Date: 30 June 2026
Our ref: 551705
Your ref: EN010148

NSIP Reference Name / Code: Tween Bridge Solar Farm / EN010148

Title: Natural England's comments for Deadline 3 in respect of the Tween Bridge Solar Farm Project, promoted by RWE Renewables UK Solar and Storage Limited.

## Annex 1

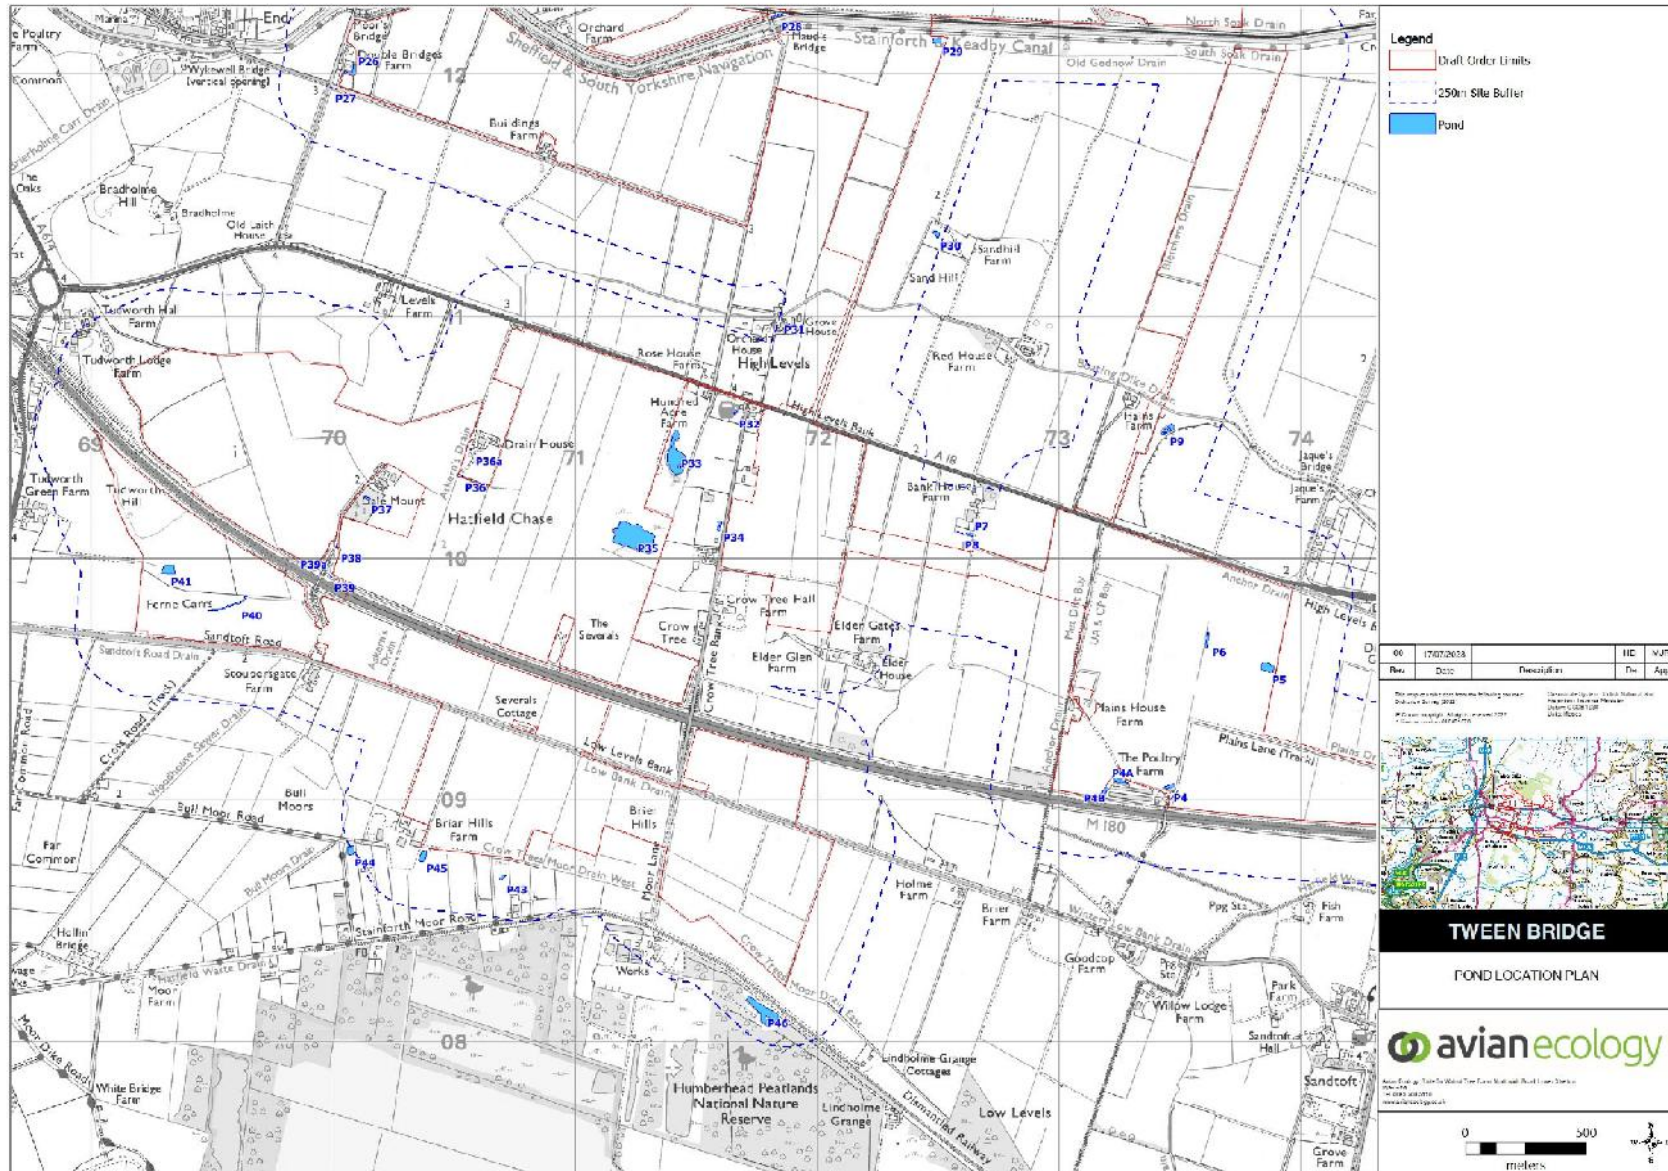
Natural England advise that this point is now resolved.	
NE23d	Protected species	Protected species – Great crested newt	<p>Natural England advise that the current survey effort is insufficient to provide robust evidence of Great Crested Newt presence/absence across the scheme footprint, with it noted that almost half of the scheme’s ponds remain un-surveyed and inaccessible. As such, it is not currently possible to conclude that Great Crested Newts are absent from the site, and their presence cannot be ruled out in un-surveyed areas.</p> <p>To address this uncertainty, we recommend that further survey work should be undertaken. Where this is not possible, a precautionary approach should be adopted, whereby Great Crested Newts are assumed to be present in the areas of highest habitat suitability where there are historical records of the species.</p> <p>Natural England recommends that where access permission to land or waterbodies are denied, we would expect that an effort is made to repeat these access requests. Evidence should be retained to show what efforts have been made to seek access and, should a full licence application eventually be needed, Natural England may request to view these records.</p> <p>Where access is continually denied, or ponds continue not to be surveyable, Natural England recommend that alternative sources of information, such as historical records and terrestrial habitat mapping, should be used to assess the ‘reasonable maximum’ population of great crested newts that the un-surveyed parts of the site could support, with the scheme designed accordingly.</p>	Amber
